**COLORADO**  
Department of Transportation  
Region 2

January 15, 2019

RE: P181/PUD183/SP181 - Rollin Ridge Estates Residential & Commercial - **REVISED**

ZONING MAP & COVER DATA
ROLLIN RIDGE ESTATES
EL PASO COUNTY, COLORADO
TC & C, LLC
17572 COLONIAL PARK DRIVE MONUMENT, CO 80132-2209

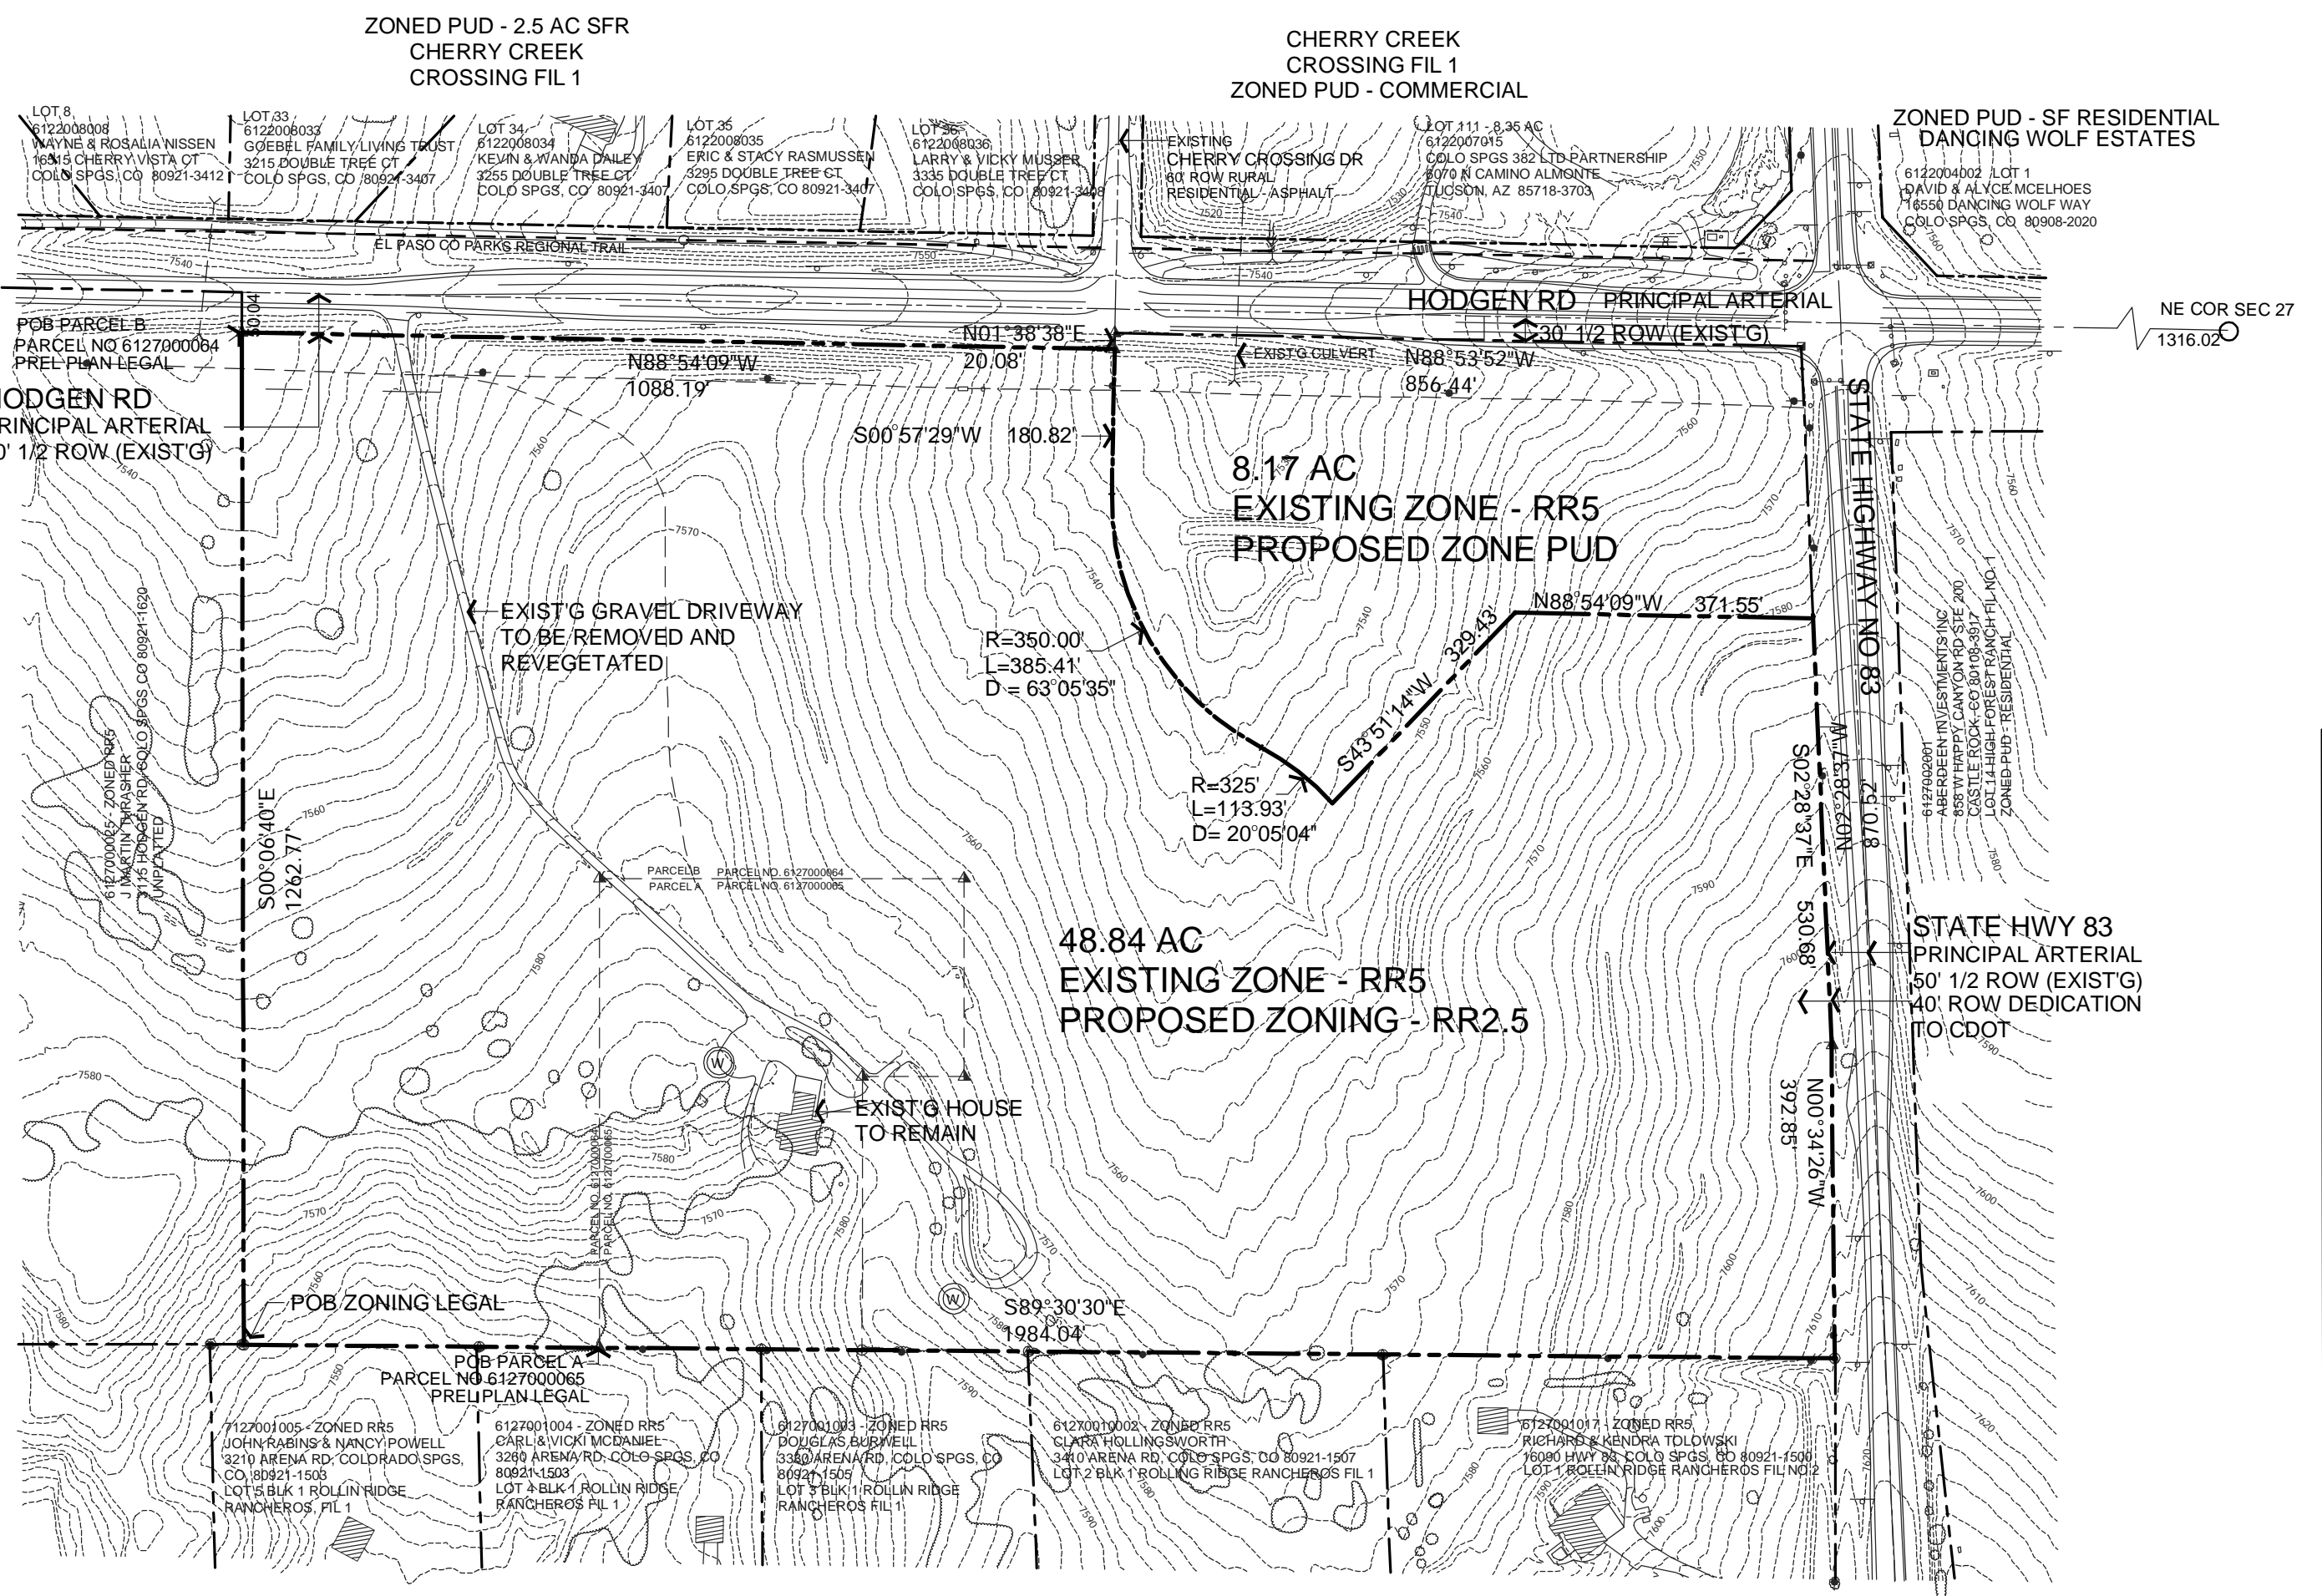
- e) *The Department notes a 50 foot distance from centerline of State Highway 83 to the subject property. We request the developer depict this distance on the upcoming development drawings.*
